Sea Link Energy Cable

**Appendix D3 to the Natural England Deadline 3 Submission
Natural England's Marine Physical Environment Advice on the Applicant's Pre-
Deadline 1 and Deadline 1 Documents**

Planning Inspectorate Reference EN020026

9th January 2026

**Figure 1. Landfall Concept Drawing (see page below)**

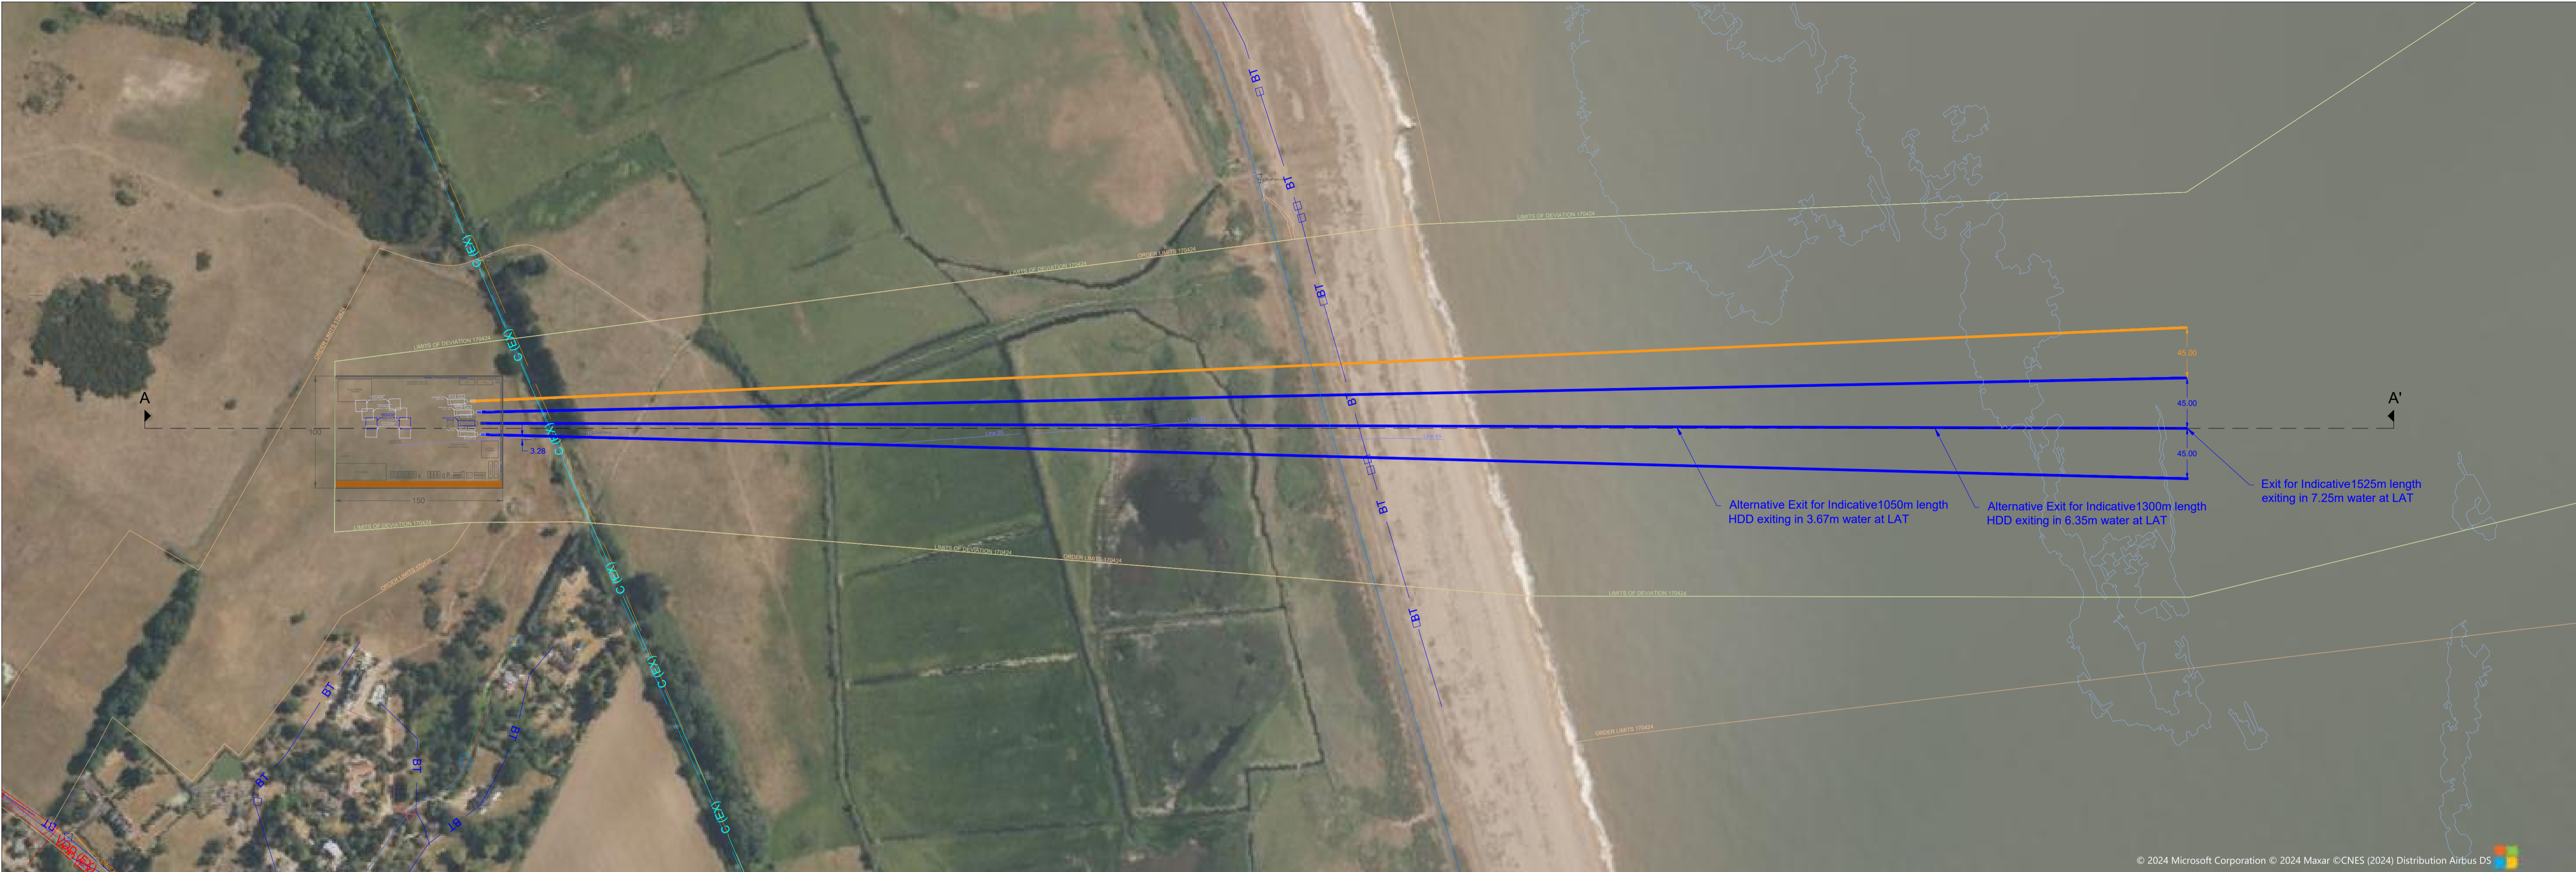
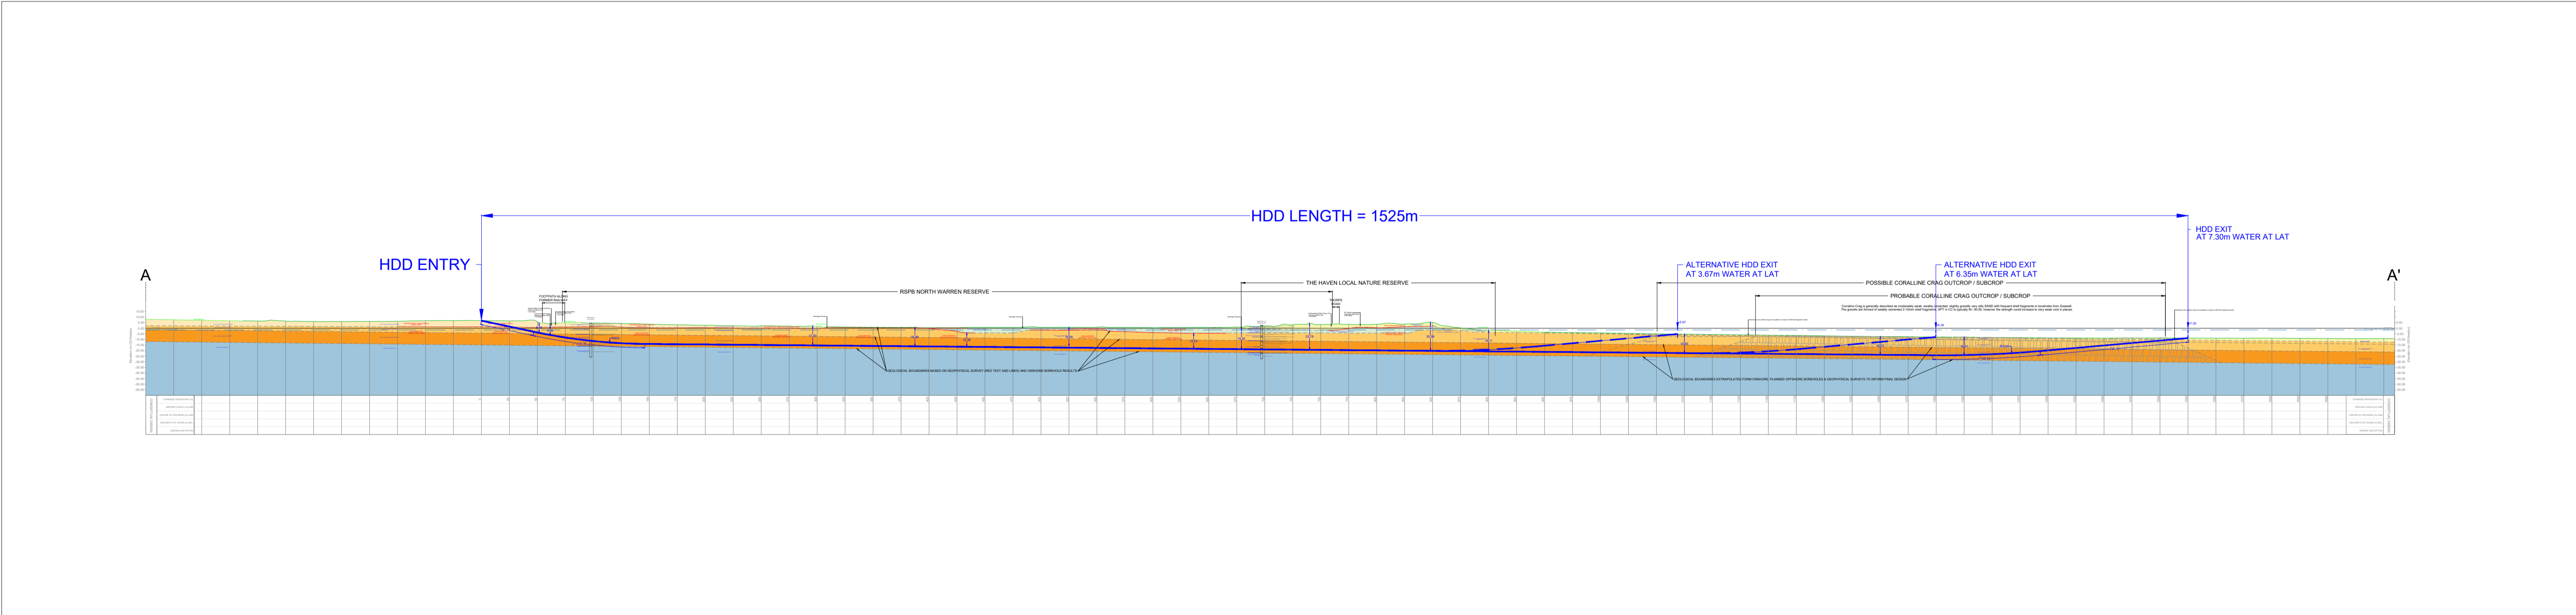
3	Figure 1, and Sections 1.2 & 3.5.2	<p>Further to our Rel Reps advice [RR-3290], we note that all three HDD exit options appear to be located in areas where Coralline Crag is present yet there is no assessment of potential impacts on the Coralline Crag due to the HDD or cable installation at landfall.</p> <p>We draw the ExA attention to previous energy projects including Sizewell C and East Anglia 1N and East Anglia 2 which have all designed their projects to avoid impacts to this unique irreplaceable geological feature only found in the area around Aldeburgh and Orford</p>	<p>In [AS-114] it is stated that the HDD exit point will target an exit location that will be designed such that there is not a risk of exiting where the Coralline Crag is at the surface. It is also stated that during detailed design, the HDD contractor will microsite the exit points based on seafloor surveys and ground investigations. However, in [PDA-037] it is stated that all 3 potential points will go through the crag, and it is not stated whether drilling through this geological feature may have any impacts on the crag. This needs to be clarified. We reiterate our earlier advice that potential impacts on the Coralline Crag due to cable installation and HDD need to be fully assessed. Furthermore, we advise that impacts to the Coralline Crag should be avoided and/or minimised when</p>

selecting the marine exit site and onwards cable installation works.
4	Sections 3.2.2 & 3.2.3	We note that the coastal erosion assessment refers to the National Coastal Erosion Risk Mapping (NCERM) project data, however, we would advise that NCERM has been superseded.	We advise that the most recent NCERM data should be considered as part of an updated impact assessment

Figure 10. Bathymetry of the wider area, showing the most important sandbanks and other features in the seabed affecting the wave propagation

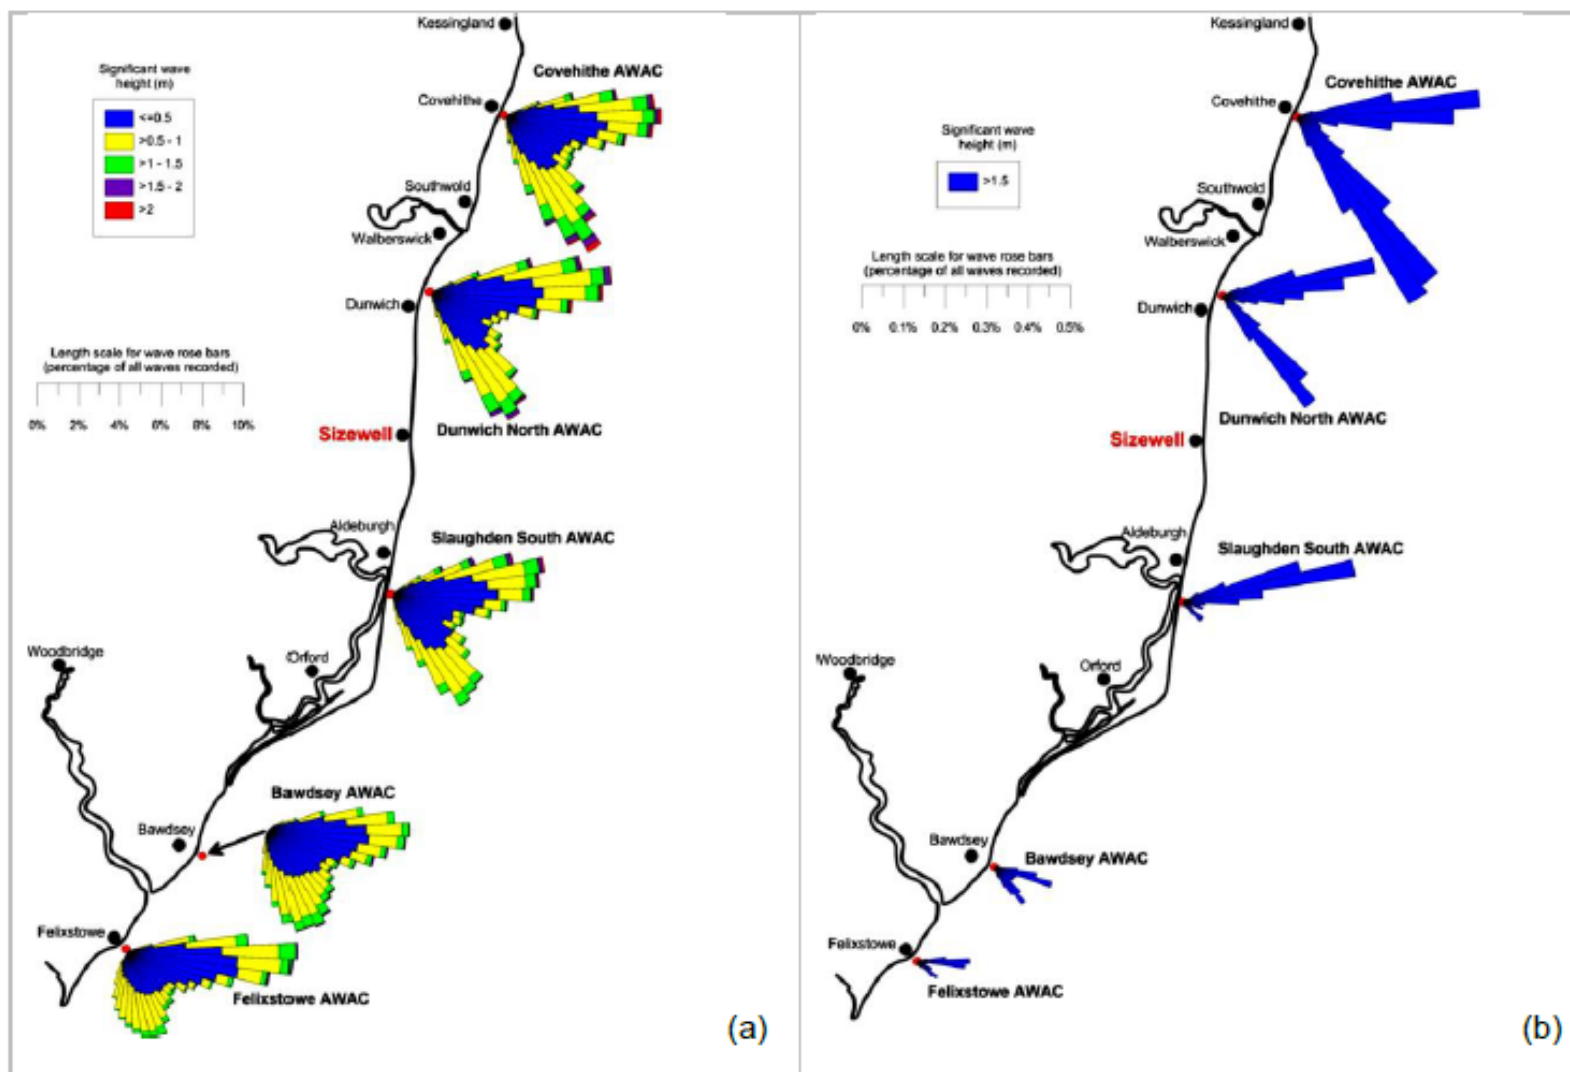
NE Ref	Section	Key Concern and/or Update	Natural England's Advice to Resolve Issue
1	N/A	The Applicant has provided the Landfall Sediment Modelling Report for Aldeburgh which is welcomed.	This issue is resolved.
2	Figures 10 and 22.	The extent to which the cable route overlaps or runs adjacent to the Aldeburgh Napes and Ridge is unclear and not presented consistently across the relevant documents. Therefore, the extent to which the Aldeburgh Napes and Aldeburgh Ridge may be affected, through the lifetime of the Project, remains unclear. For example, through changes to waves, hydrodynamics, and sediment transport due to the placement of cable protection or adjacent to the sandbank systems.	The extent to which cable installation and cable protection could affect the Aldeburgh Napes and Aldeburgh Ridge needs to be clarified. Given the complexity of this sandbank system and the movement of sediment within and around it, it is important to understand both its morphodynamics and, in turn, the nature of any impacts on it due to the placement of cable protection measures.
